File Ref. No: BFS16/1987 (11543)
TRIM Doc. No: D16/70457
Contact: Station Officer C. Wheatley

14 September 2016

**Development Application Modification Application
Botany Industrial Park Subdivision (DA 30/98 MOD 3)
16-20 Beauchamp Road Matraville**

Figure 5: Proposed Modification with Changes Indicated in Red (DA 30/98 MOD3)

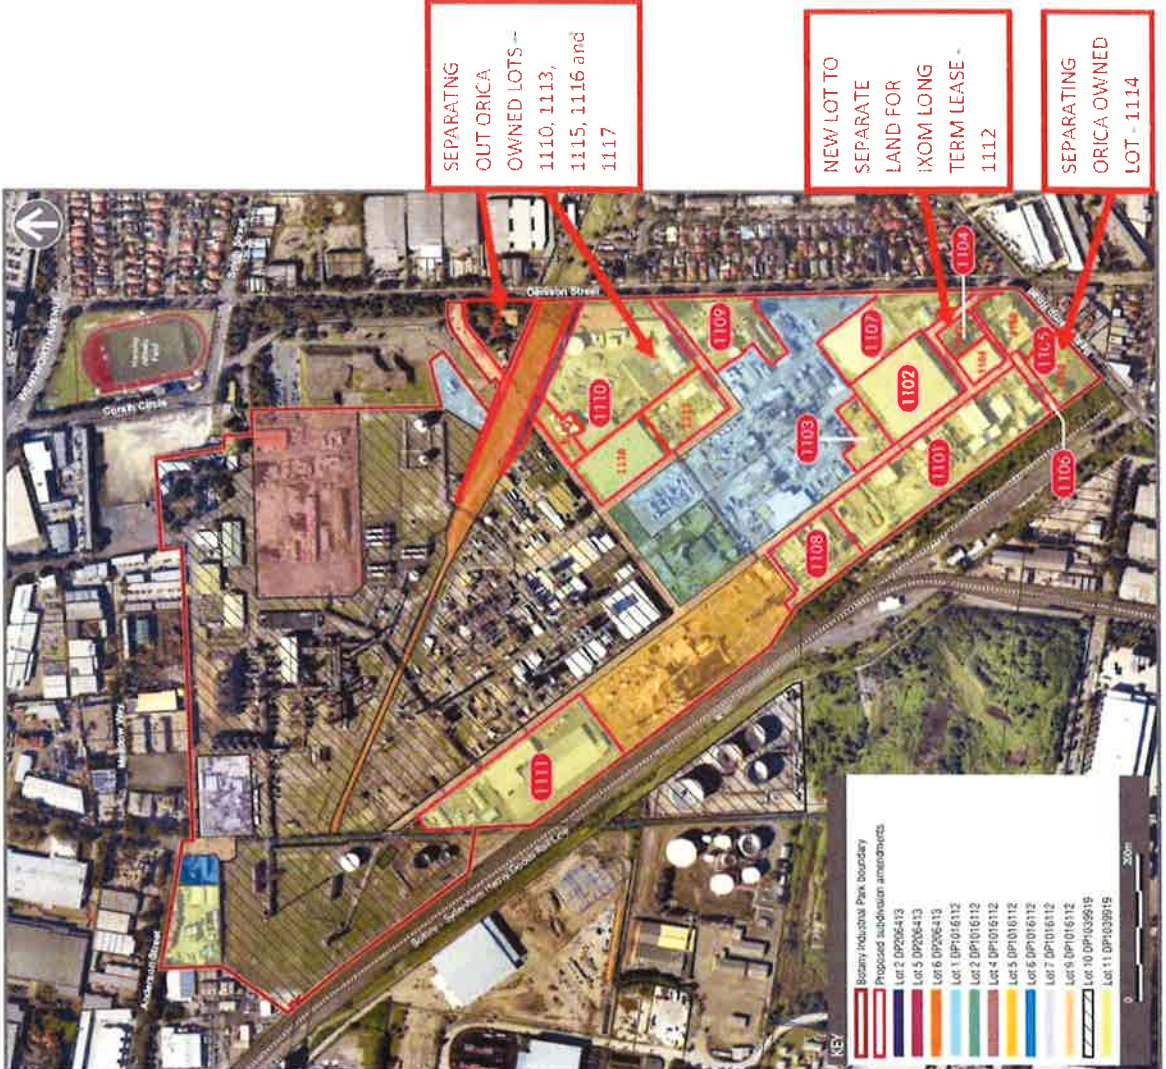
1. FRNSW has concerns that the proposed subdivision of existing **Lot 1110** – into Lots 1110, 1115, 1116, 1117 and 1118; **Lot 1104** – into Lots 1104 and 1112; **Lot 1105** – into Lots 1105 and 1114; and **Lot 11 (DP 1039919)** – into Lots 1113 and 1119, may present operational difficulties as a result of problematic emergency access to the new Lots.

Due to the BIP being a large site containing hazards associated with the type of products located within the site, FRNSW would require specific emergency access details for the proposed subdivisions (and throughout the BIP as a whole) in order to provide detailed FRNSW comments on the proposed subdivision.

2. The proposed subdivision of Lot 1110 identifies Lot 1115 to be dedicated to segregating the firewater tank that services the entire BIP from Orica's other assets. FRNSW is concerned that the installed firewater tank, and possibly other fire safety measures affected by any proposed subdivision of Lots and/or ownership, has the potential to create non-compliances with applicable codes and standards (e.g. Clause 4.1.1 of Australian Standard (AS) 218.1-1999). In addition, the sub-division has potential to be problematic with regard to ensuring on-going and satisfactory maintenance of existing (and future) fire safety measures within the BIP. FRNSW is concerned that as a result of the proposed changes in ownership of Lots and/or infrastructure involving Orica, IXOM and BIP (or any other current or future Lot owners), future issues associated with ownership and the ongoing costs of maintaining the site-wide fire safety measures located across the BIP's near 74 hectares of land may arise. Such an outcome would may have a deleterious impact upon the integrity and reliability of critical site fire systems.

FRNSW recommend that a binding covenant be created prior to development consent to ensure all fire safety measures located within any part of the BIP, either existing or future as a result of the proposed subdivision, are maintained as per the intent of Clause 182 of the Environmental Planning and Assessment Regulation 2000. As the above Clause relates to fire safety measures in buildings or the built environment, the creation of a covenant, which is specific to the proposal, is recommended to also encompass the non-built environment and/or any Lot which is incorporated within the BIP. This recommendation aims to ensure that all fire safety measures are regularly tested and maintained throughout the BIP to ensure its reliability, regardless of ownership.
